WEST SUSSEX COUNTY COUNCIL CONSULTATION

TO:	Arun District Council FAO: Amber Willard
FROM:	WSSC – Highways Authority
DATE:	16 October 2025
LOCATION:	Land South East of St Marys C of E Primary School Crookthorn Lane Climping
SUBJECT:	CM/34/25/PL Relocation of visitor facilities including car parking, toilets, cafe and ancillary development. This application is a Departure from the Development Plan, may affect the setting of listed buildings and is in CIL Zone 5 (Zero Rated) as other development.
DATE OF SITE VISIT:	n/a
RECOMMENDATION:	No Objection

DETAIL OF CYCLE PARKING 1:50

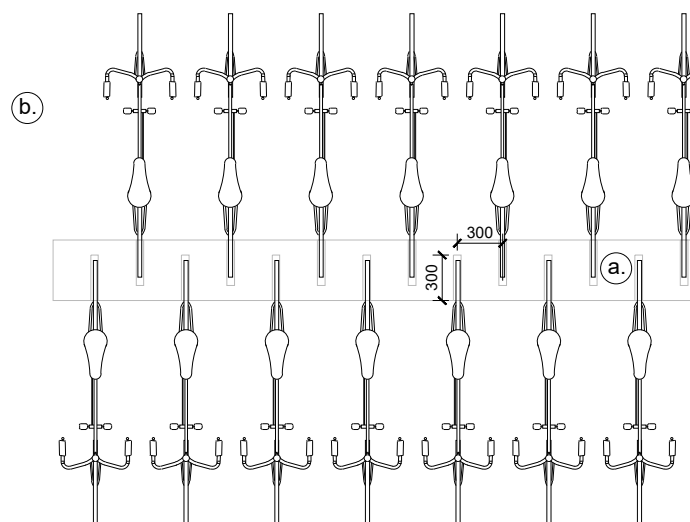
Whilst no longer a planning matter WSSC welcome the inclusion of EVC points. Cycle hoops will also be provided to encourage staff of which there will be 10 members to travel sustainably and provide a space for cyclists who are passing by or visiting. The site links well into the existing cycle infrastructure on the A259 and the on carriageway signed route on Crookthorne Lane leading to the bridge over the River Arun.

Arun SPD recommends 2 spaces for staff and 6 for visitors based on the café sqm. However more should also be provided for visitors however this number cant be specified and will likely require a minimum number of 10 hoops (20 spaces) as a starting point, with space to add further hoops if required.
